KITTITAS COUNTY

DEPARTMENT OF PUBLIC WORKS

MEMORANDUM

TO: All Staff
FROM: Public Works Plan Review Team
DATE: June 7th, 2023
SUBJECT: BL-23-00009 Rarden

BOUNDARY LINE ADJUSTMENT BL-23-00009

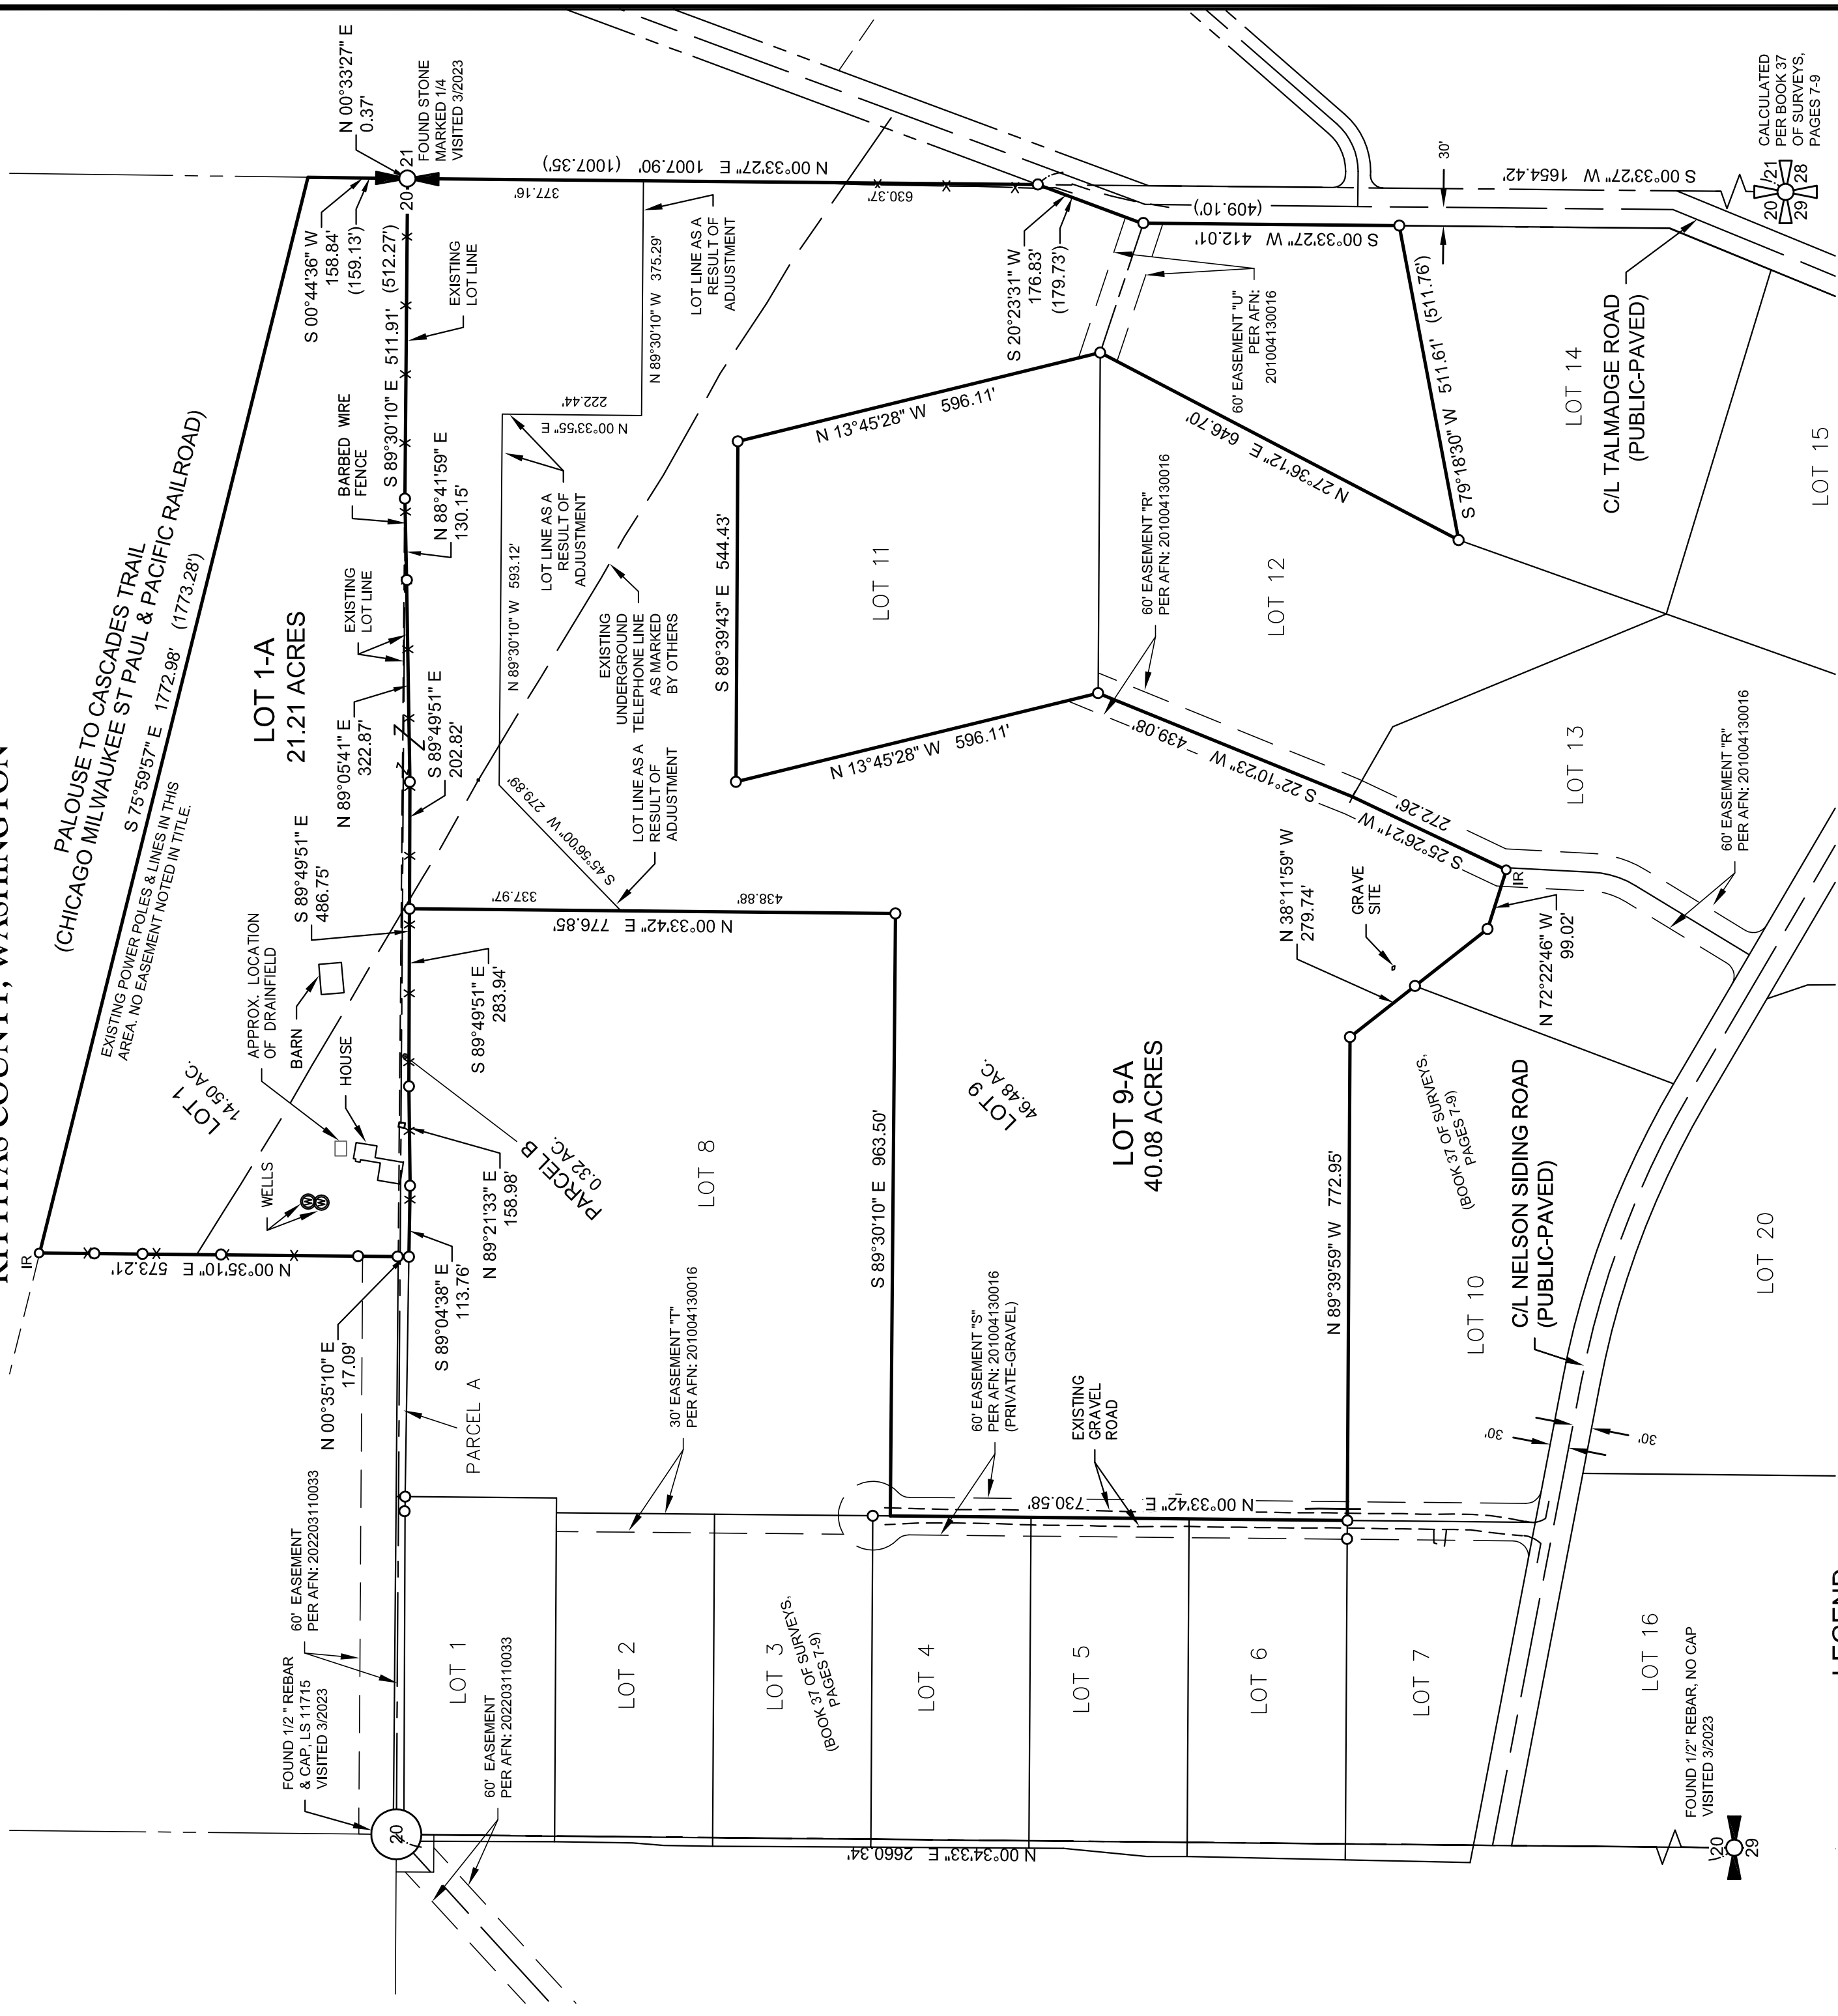
| <p>SURVEY</p> | <p>Provided site plan only, comments reserved for later date when survey is provided for final review. (KH)</p> <p>UPDATE 7/31/2023</p> <ol style="list-style-type: none"> 1. A detail window for the 0.37' line located at the East quarter corner of section would clarify things. 2. The North line of SE1/4 should be shown, in order to tie section corners to the survey. 3. Identify and note discrepancies with various bearings and corner positions (per discussion with Mr. Pierce). |

| | Of note: While a basis of bearing statement that references a single point and State Plane Coordinates is insufficient to serve as a true basis of bearing, it does meet the requirements of state law. |
